Engineers Comments Regarding Condition 6

Subject: Planning Consultation on: WA/118/21/DOC

Application No: WA/118/21/DOC

Site Address: Willows West Walberton Lane Walberton BN18 0QS

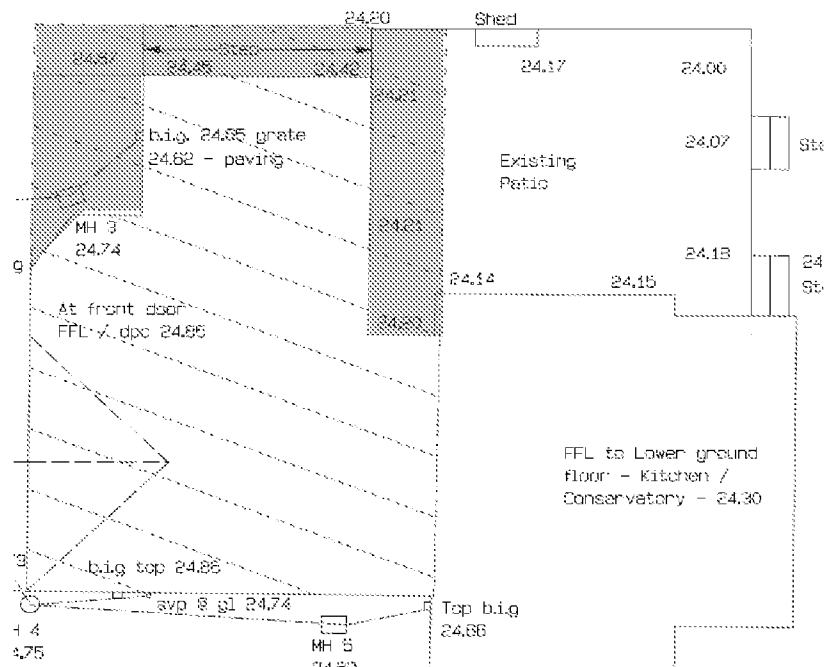
1. Please supply winter groundwater monitoring results.
2. Please supply construction detail drawings of; pipe bed and surround, catchpits, attenuation tanks, flow restriction device, and headwall.
3. Please extend layout to show point of discharge at watercourse.
4. Please provide bed levels of the watercourse.
5. Please label layout with invert level of proposed outfall to watercourse.
6. Please label all pipes with diameter and fall.
7. Please provide a catchpit upstream of the attenuation tank.
8. Please label invert and cover level of tank. Please also state required attenuation tank dimensions. Flotation calculations may be required to support design.
9. Please supply evidence of consent for the proposed outfall.
10. Please confirm if a separate outfall is proposed for WA/119/21/DOC
